Subject: FW: Blue Bush (Tellus) - planning comments

Subject: Blue Bush (Tellus) - planning comments

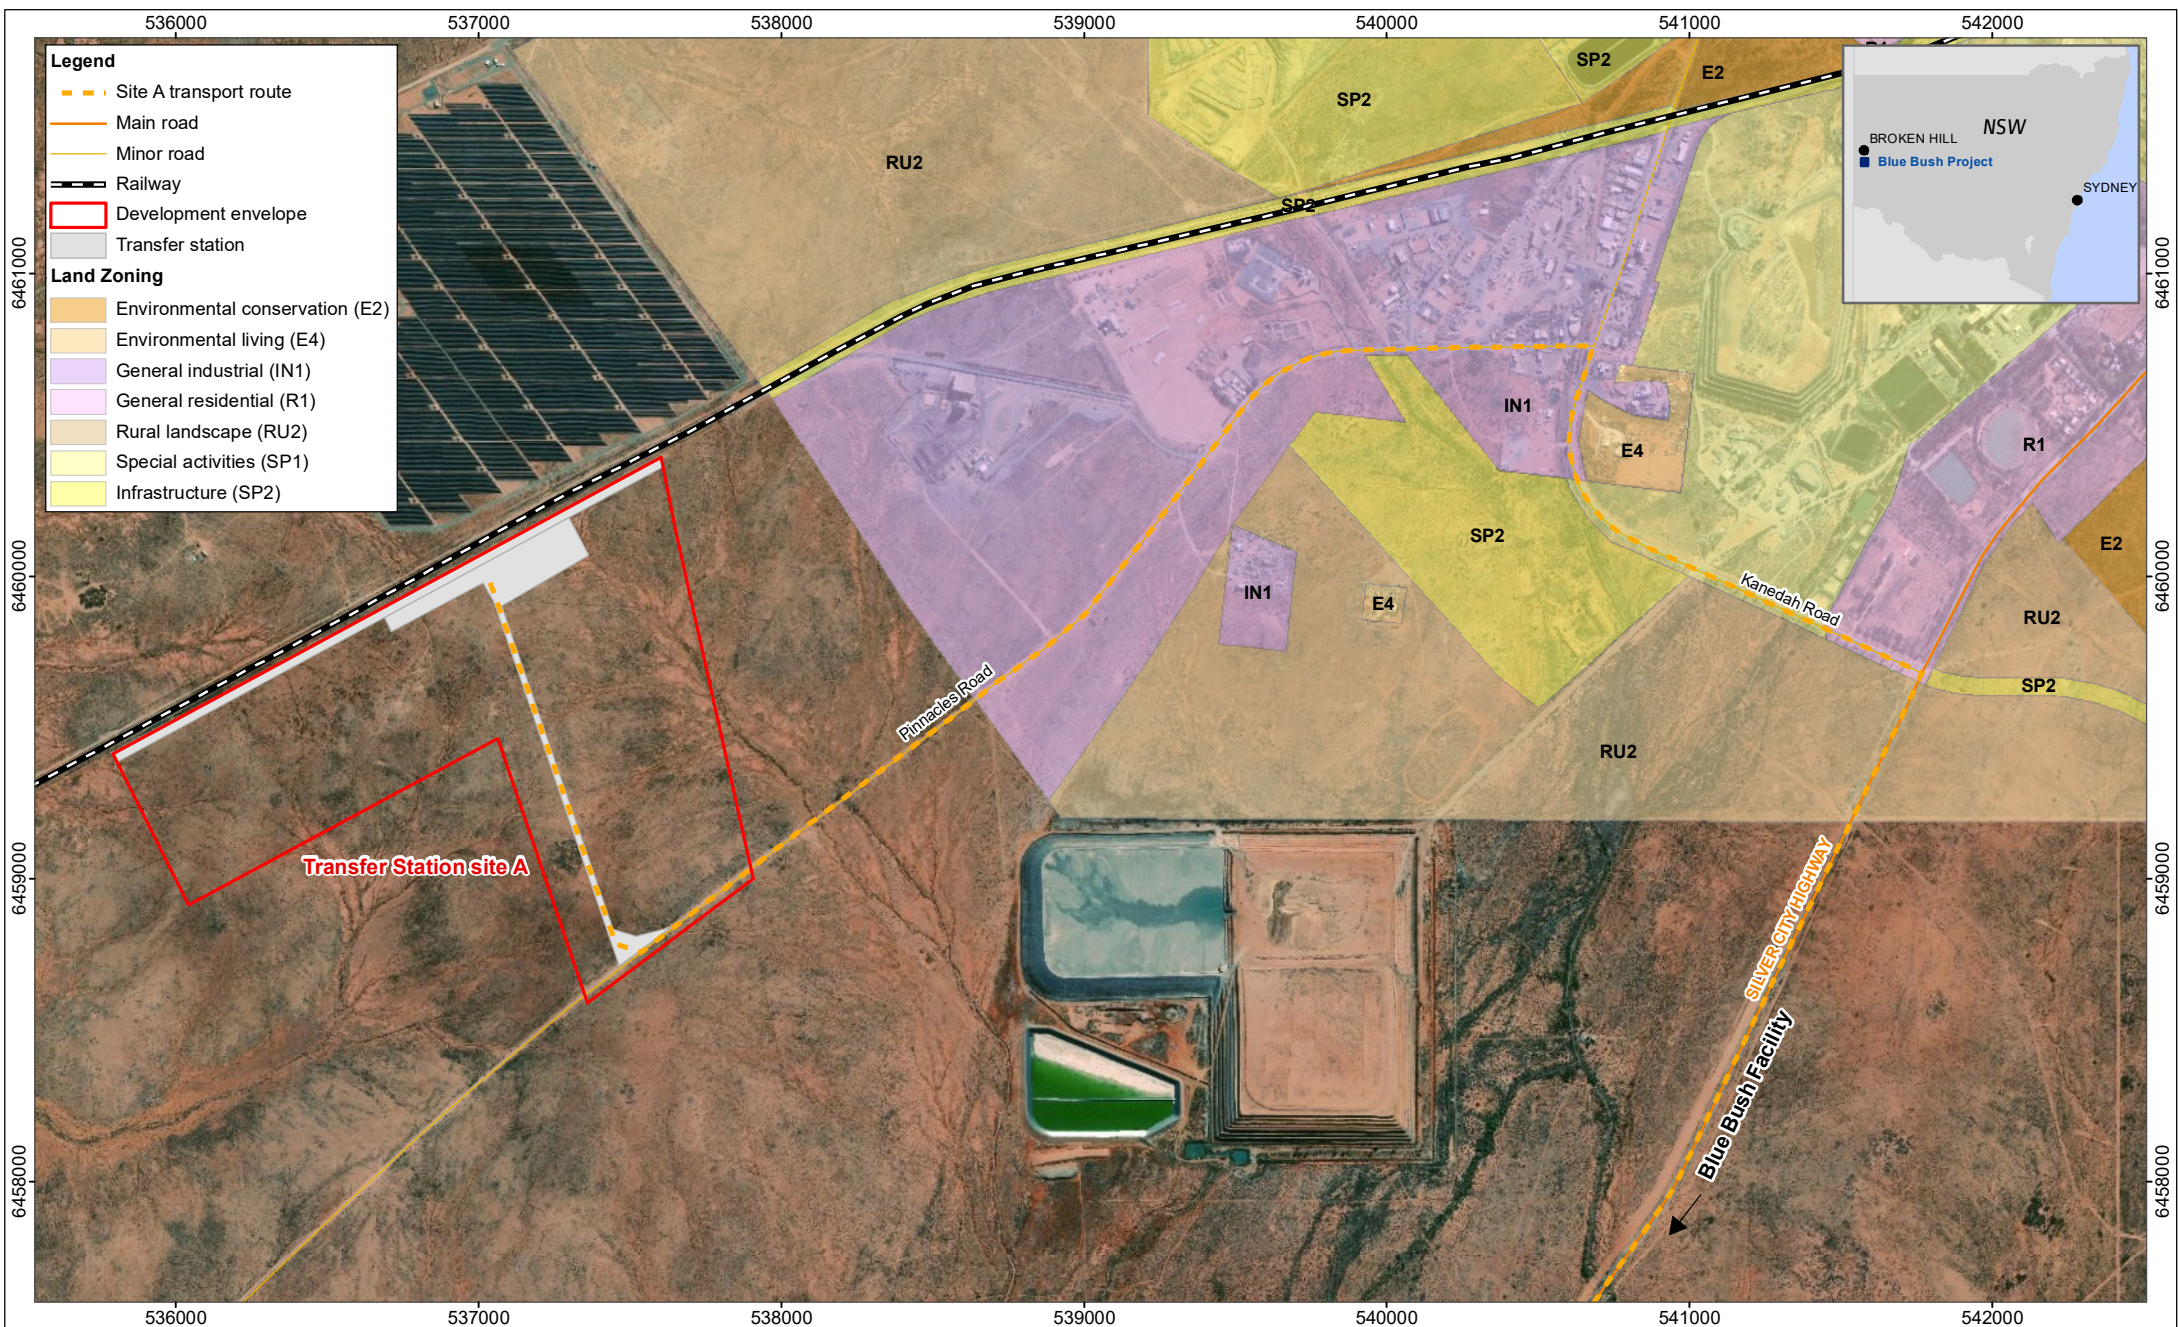
We note that both the transfer station and facility itself are not located within the LGA, and over 5km from the nearest residential area in Broken Hill. Waste will be received at the Transfer Station by rail, and then transported by road (truck) along the Silver City Highway to the repository facility.

Council wishes to raise an issue for further consideration once an EIS is developed, in regard to truck movements through the LGA.

Council requests that detail be provided on type/size of trucks and estimated number of truck movements. Council will need to consider additional use of Pinnacles Road and Kanandah Road, and subsequent impact on road condition and maintenance requirements.
